# Planning Services Sign Permit Review Form

Date of Submittal	Application Number	Applicant	Landowner
<b>4/8/2022</b>	<b>SUB2204-0003</b>	<b>Burchette Sign Co</b>	<b>Seymore Richard G Trustee</b>

Contact Person	Contact Number	PIN Number	Sign Location
<b>Tim Burchette</b>	<b>336-996-6501</b>	<b>9594-33-0677.000</b>	Monument Sign – E. Property line along NC 24-87, Directional signs NE property line and at entrance

Reviewed By:	Date of Review	Review Results
<b>Sarah Arbour</b>	<b>4/22/2022</b>	<input type="checkbox"/> Approved <input checked="" type="checkbox"/> Denied

1 1ST FLOOR - SITE PLAN

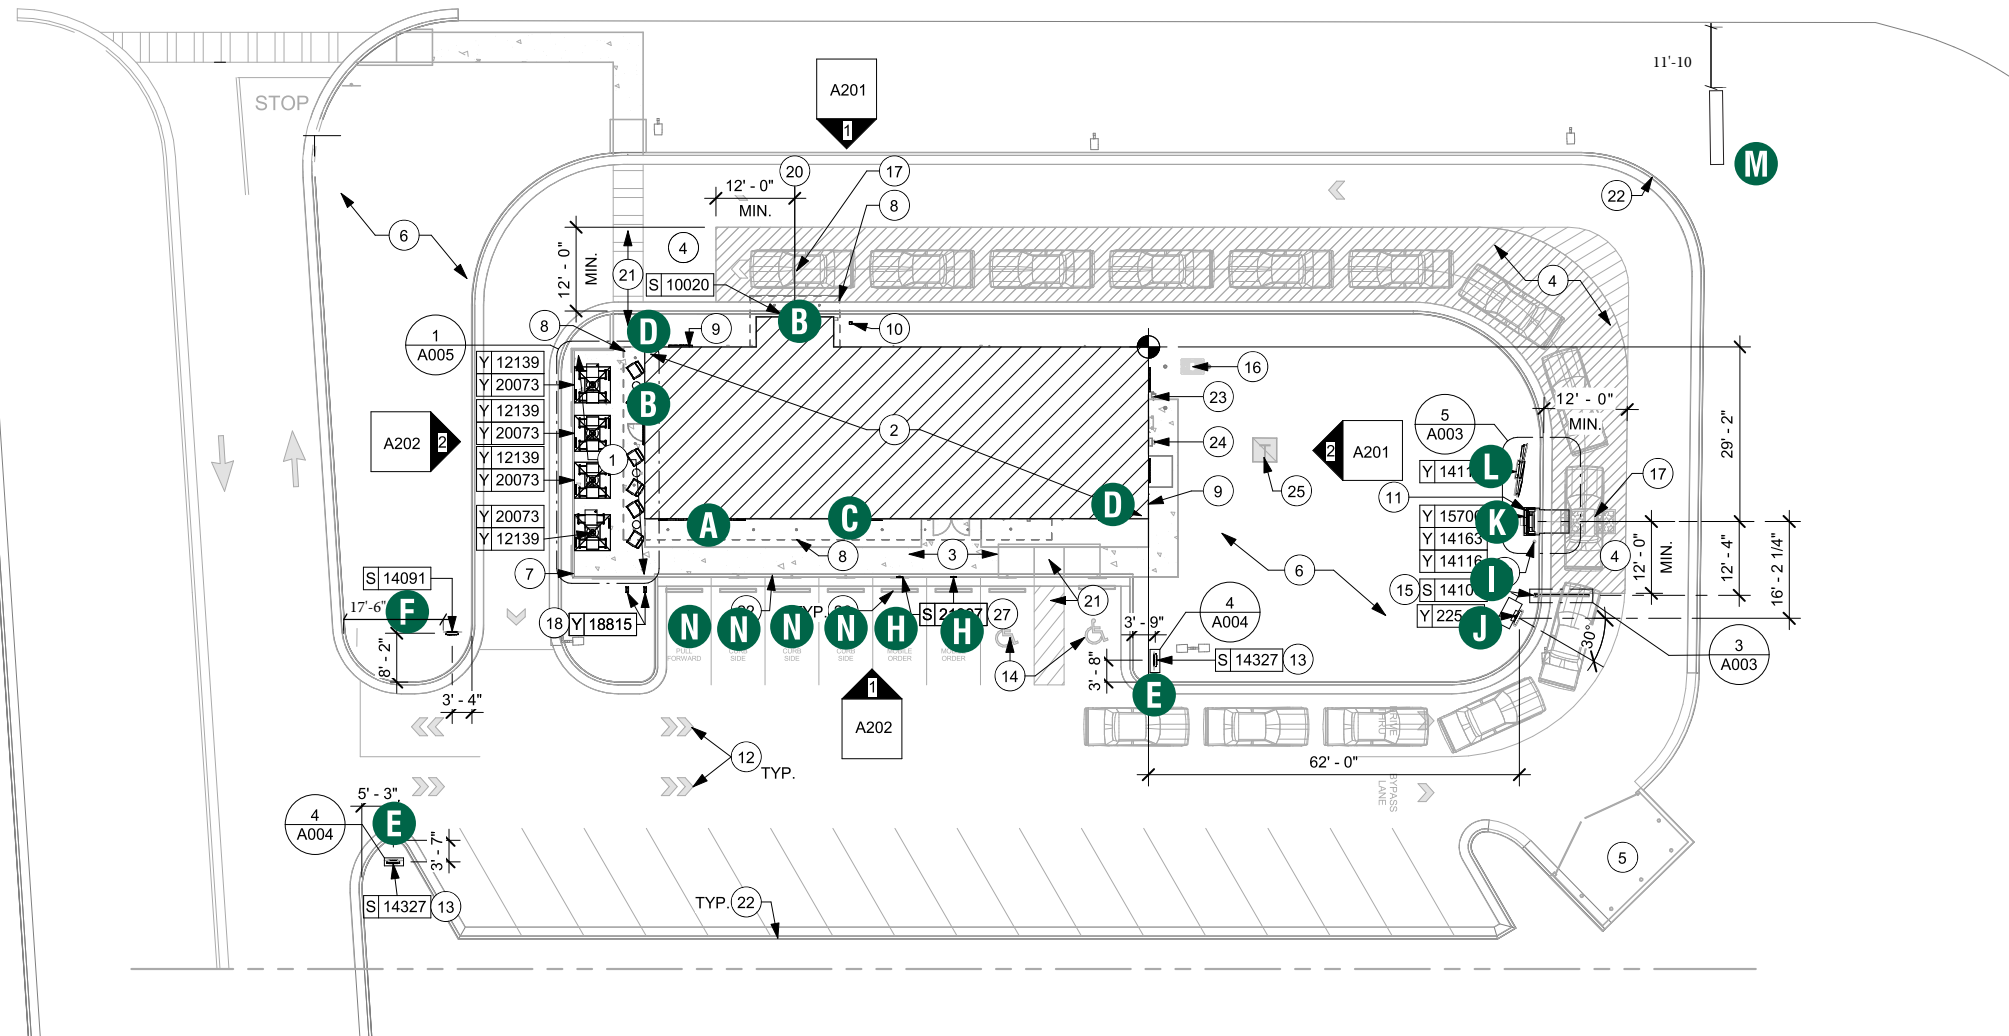
Comments	<p>-Please provide the setback from the ROW and Property lines for the 15' ground sign and 2 of the directional signs. The directional sign proposed for the interior of the property was not considered in this review.</p> <p>-Only one directional sign is permitted per project. Either the sign at the corner of NC 24-87 may be present, or the directional sign at the driveway may be present. Both will not be permitted.</p> <p>-Please confirm that the landscaping required by in the Highway Corridor Overlay is either existing or will be in place when sign is constructed. The requirements for the landscaping are below.</p>
----------	---
